FROM: Katie Kurek

SUBJECT: BE/83/17/PL - 1 No. dwelling & associated parking.

Land Adj To 385, Chichester Road and 24 Ashurst Close, Bersted, West Sussex, PO21 5UJ

DRAWING TITLE
Site Plan and Street Elevations

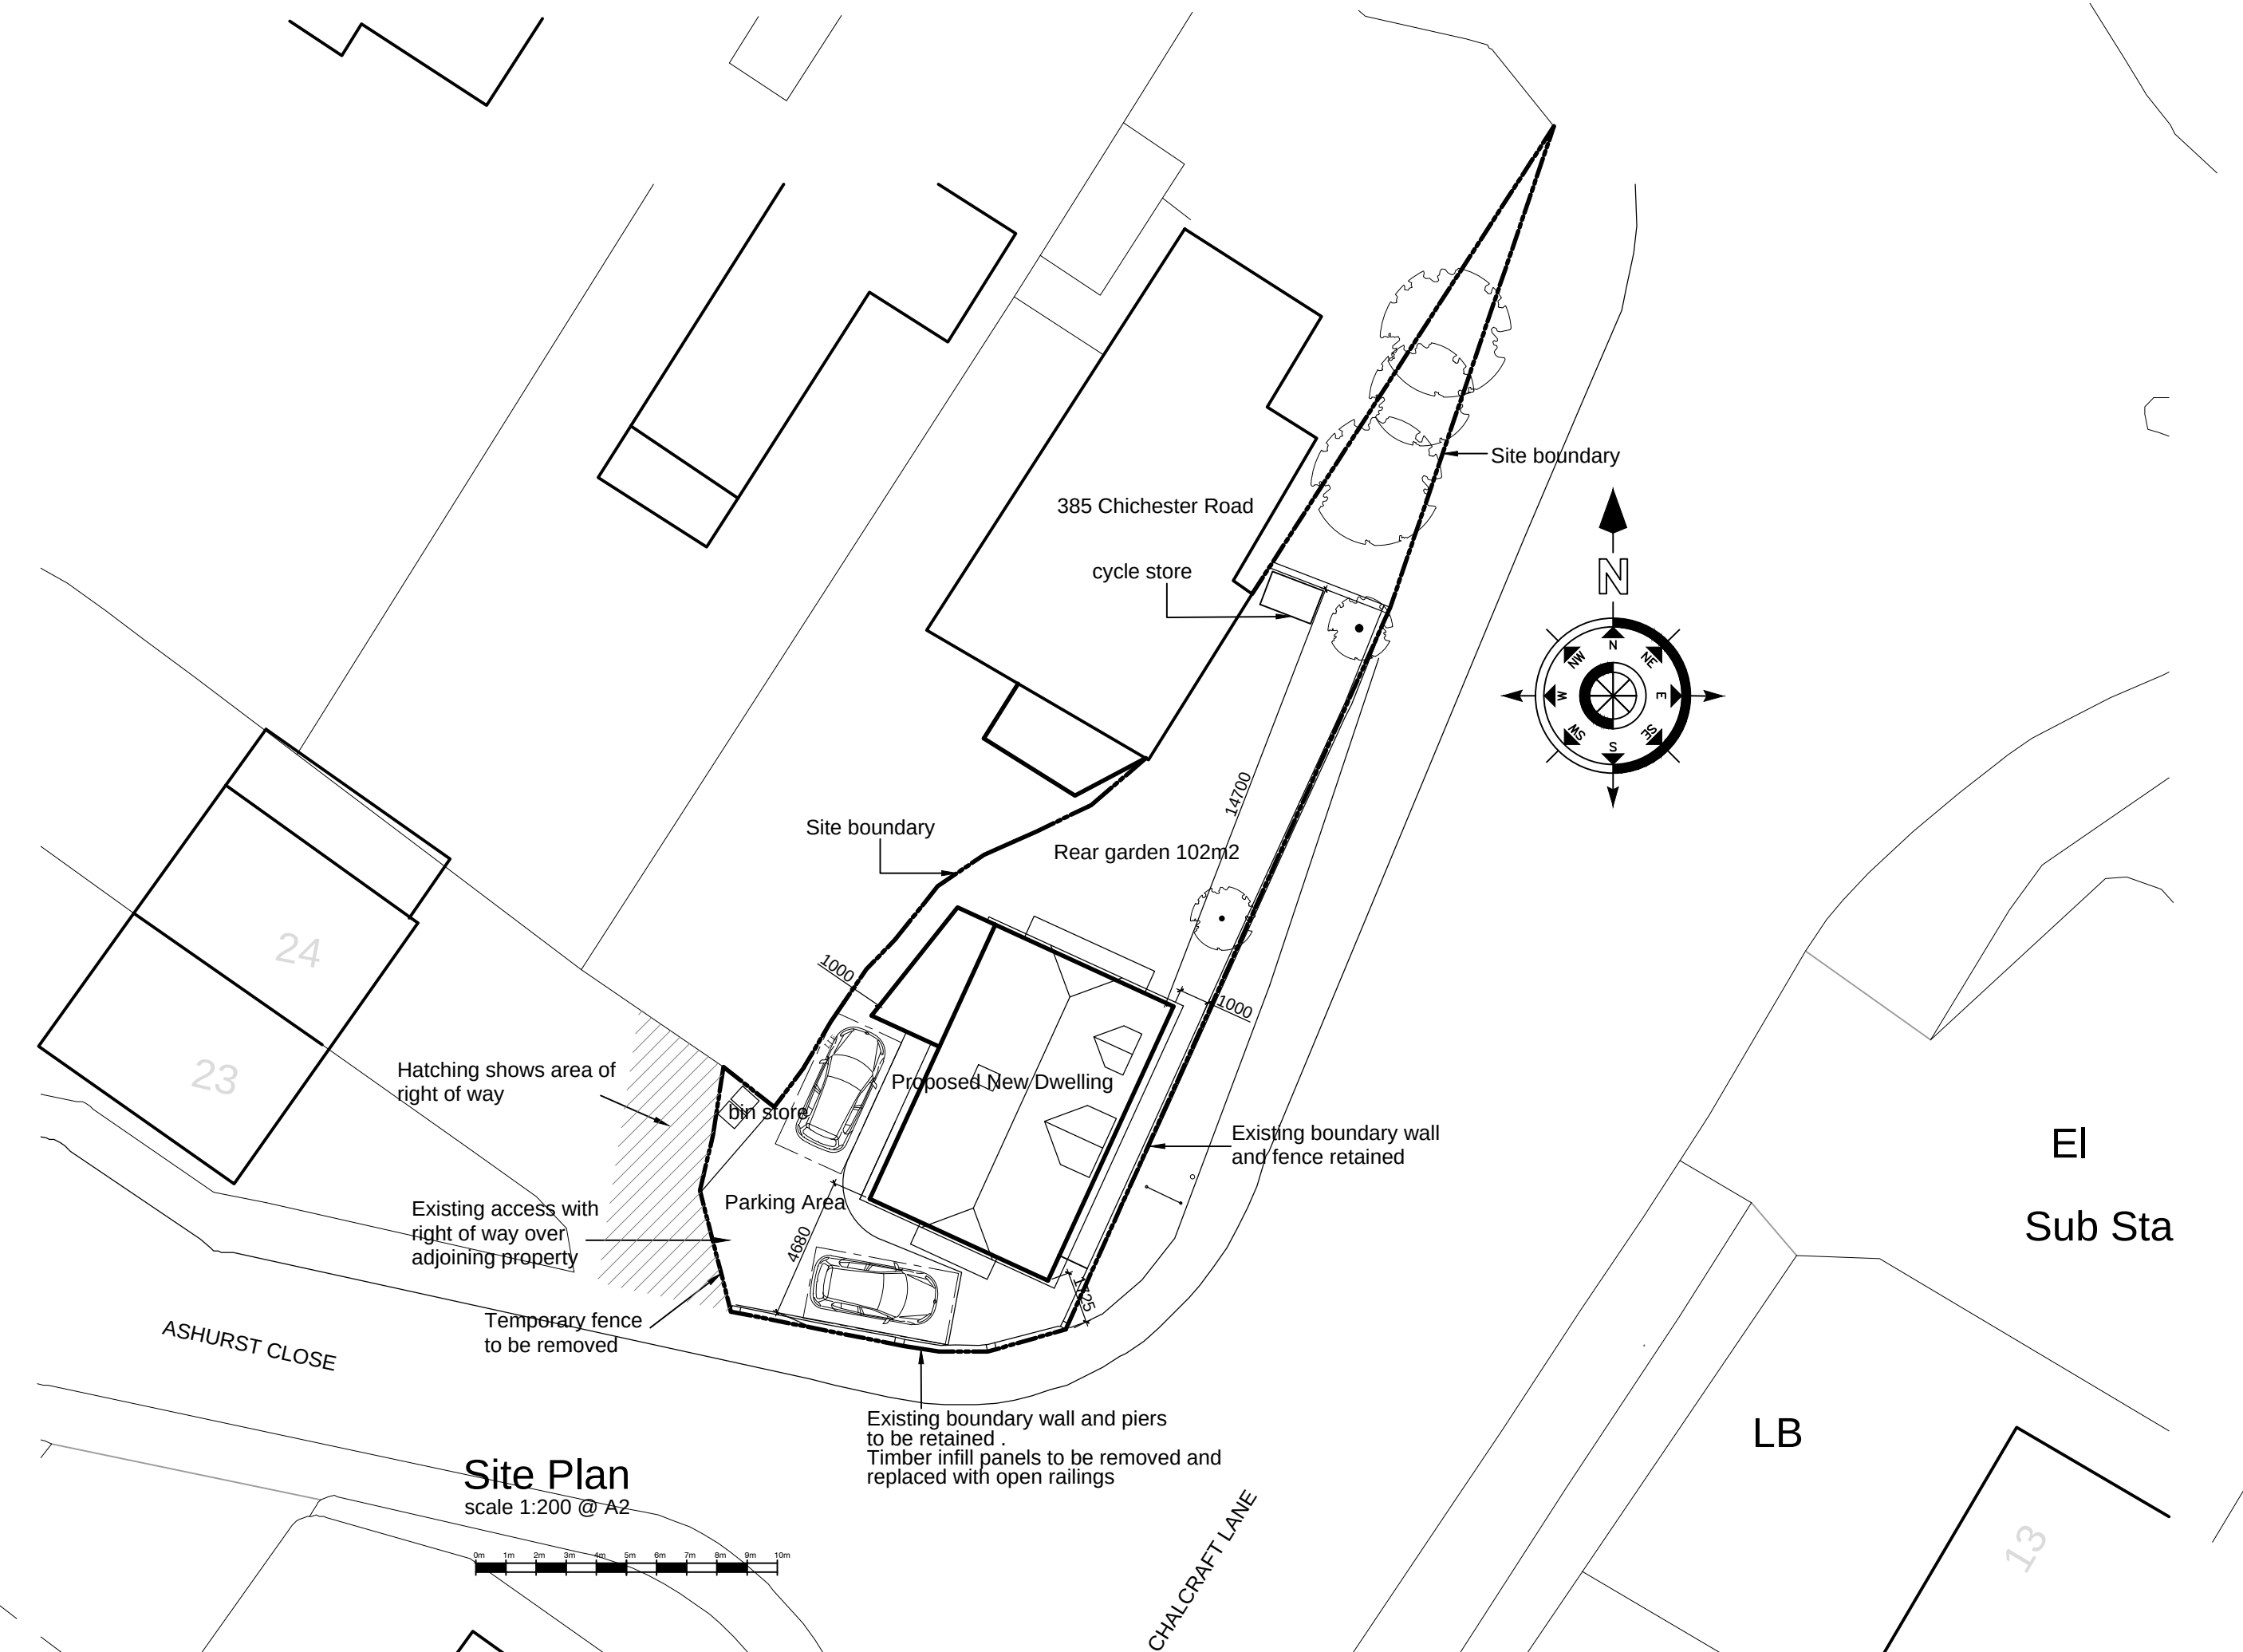
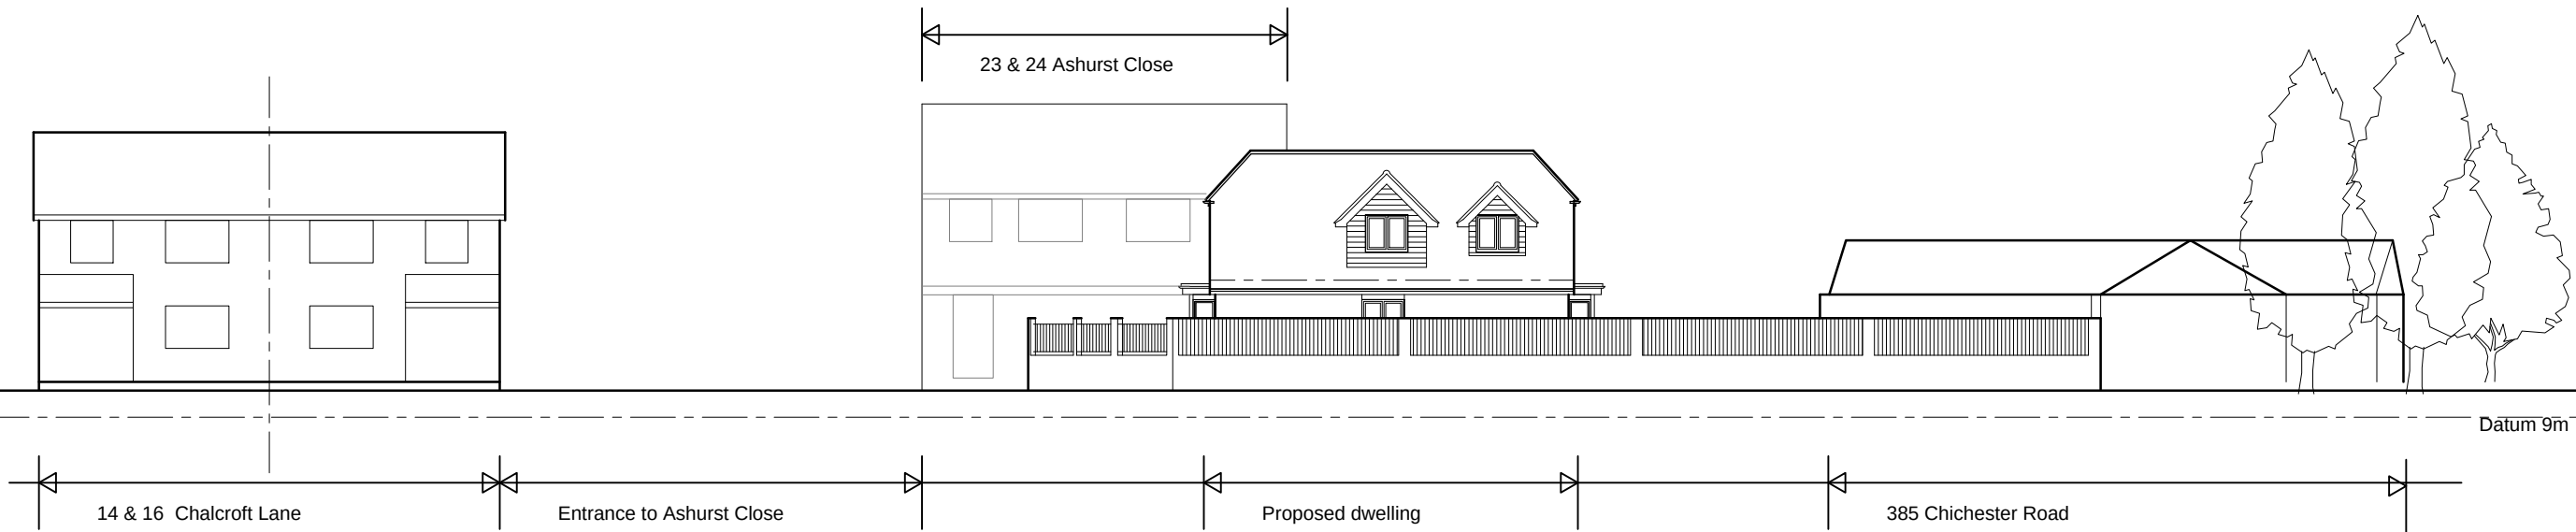
On the basis that the two off-street car parking spaces are allocated to the new dwelling this meets with the anticipated demand for a dwelling of this size and location. From an inspection of the plans the shared right of way could be used to provide space for a turn on site so that cars can exit on to Ashurst Close in a forward gear. Whilst this has not been demonstrated the LHA appreciate that neighbouring accesses have been operating in a similar way with no turn on site without evidence of highway safety concern.

Car parking space (details approved)

No part of the development shall be first occupied until the car parking has been constructed in accordance with the approved site plan. These spaces shall thereafter be retained at all times for their designated purpose.

Cycle store detail - revised proposal

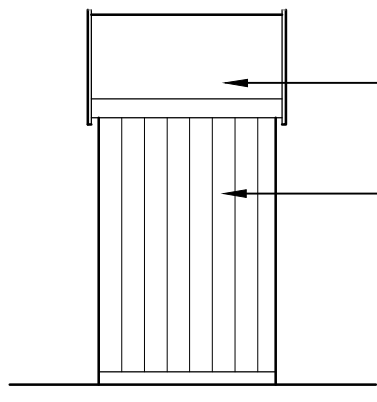
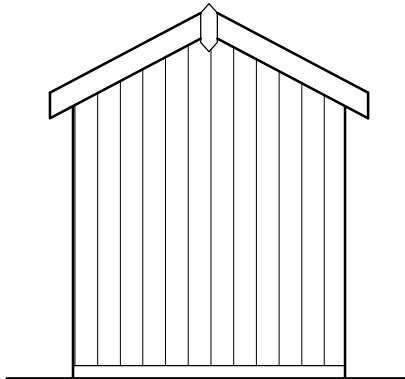
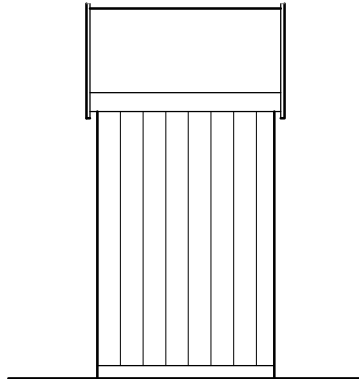
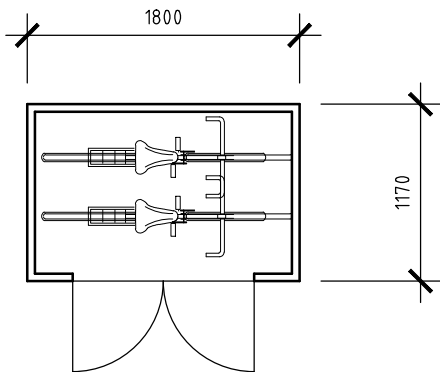
A shed will be provided to the rear garden to provide secure and covered bicycle storage for 2 x cycles. The LHA are satisfied that a sustainable mode of transport has been encouraged for the development and would advise that this facility is maintained in perpetuity via condition.

Cycle parking

No part of the development shall be first occupied until covered and secure cycle parking spaces have been provided in accordance with plans and details submitted to and approved by the Local Planning Authority.
